From The Member-Secretary,
Chennai Metropolitan
Development Authority,
8 Gandhi Irwin Road,
Chennai-600 008.

Letter No. C4/19355/98 Dated: 11.11.98.

Sub: CMDA - Planning Permission - Construction of Training Institute building for Mentally retarded children in S.No.860/1A1B of Korattur village for Navajyothi Trust - D.C. & other charges to be remitted - Reg.

TERRACE PLAN

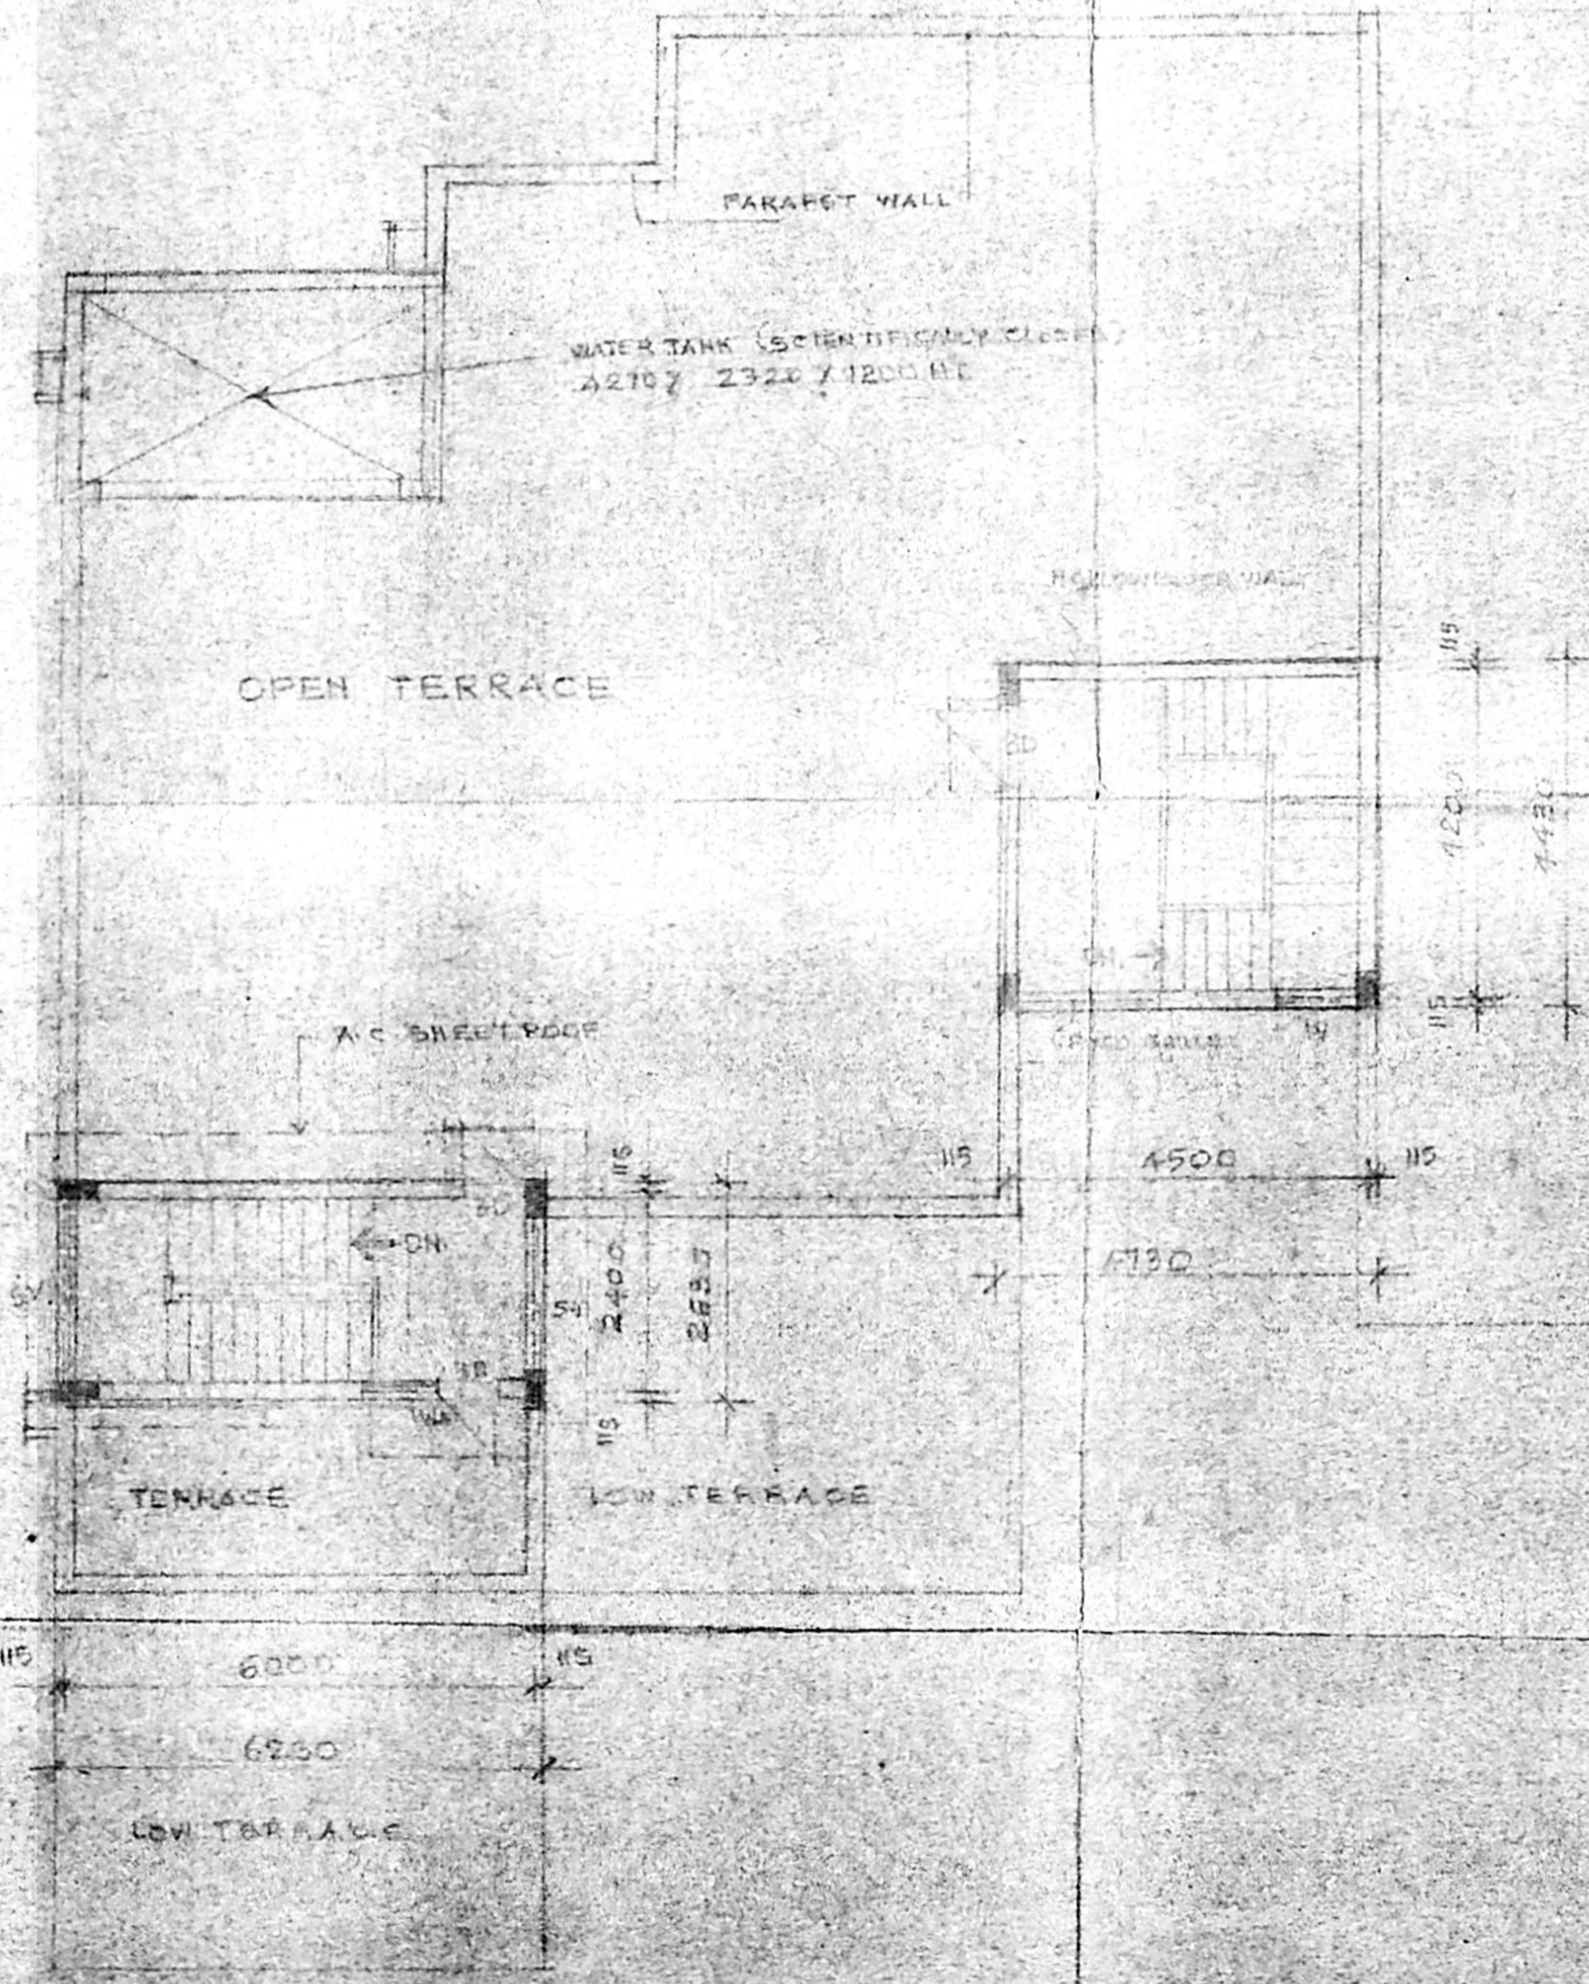
1. The shape & size of the site boundary varies with the hand-drawn sketch enclosed. This needs clarification & correct site plan to be furnished with surrounding road network as available.

- ii. Overall measurements (including wall thickness) ~~for~~ from the proposed building in the site plan.
- iii. Satisfying corridor width requirements.
- c) While allotting the site one of the conditions that the ~~xxx~~ land shall be utilised for the purpose specified there ~~is~~ within a period of one year from the date of taken possession of the land. Hence the land was handed over on 27.4.98/20.5.96 (date available in the sketch) But the PPA was applied on 10.9.98 (to local body). This need to be clarified. Any fresh order is obtained to be produced.
- d) You are also informed to remit necessary charges for reclassifying the site under reference from Primary Residential to institutional use zone and in this regard you are advised to call on reclassification division in CMDA.
- e) Undertaking deed duly notarised in the formate prescribed.
